Consultation Response from KC, Conservation & Design
2023/91527 31, Chapel Hill, Linthwaite, Huddersfield, HD7 5NJ
Listed Building Consent for change of use and alterations to former church (B8-storage) to 9 residential units (C3) and formation of car park(within a Conservation Area)
Date Responded: 10/6/25 Responding Officer: S Campbell Responding Ref:

Drawing:
Window
Details

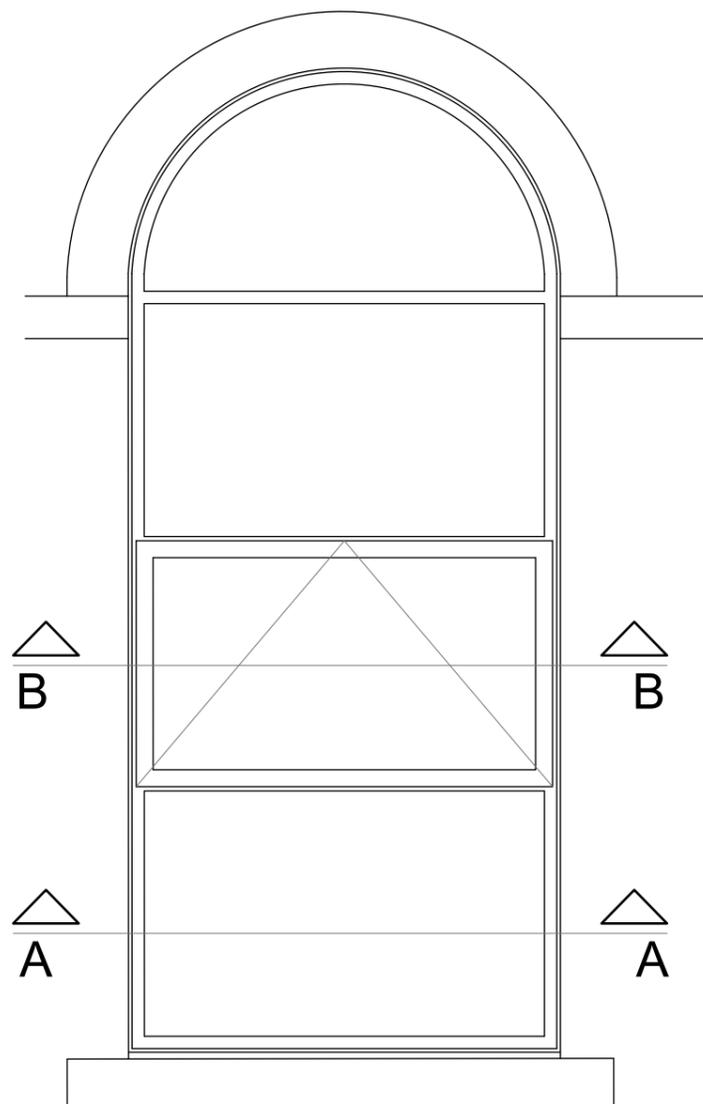
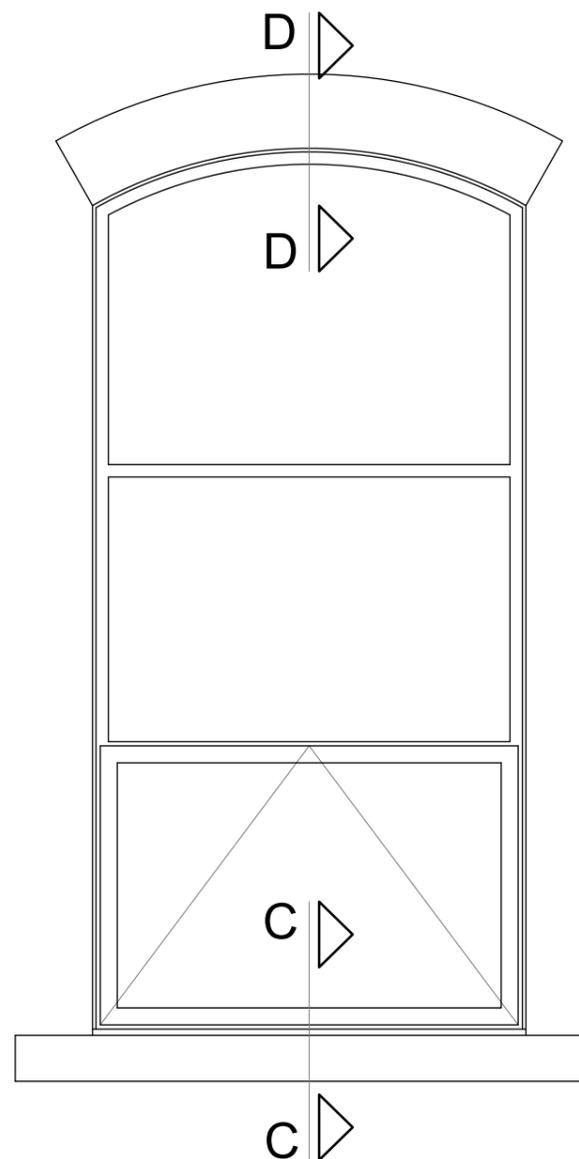
Regarding the window alterations, the applicant has provided amended details which are generally acceptable but there is some discrepancy regarding the use of timber or metal.

I note that there are proposals for metal frames for most of the windows and encapsulation is proposed for treatment of any original or early stained or coloured glass. This is considered acceptable provided that the outer frames use a metal framework as the agent has confirmed can be provided.

It is recommended that a Condition should require further details to be submitted for window details, sections, method of opening and a sample of the encapsulation prior to production of all the windows.
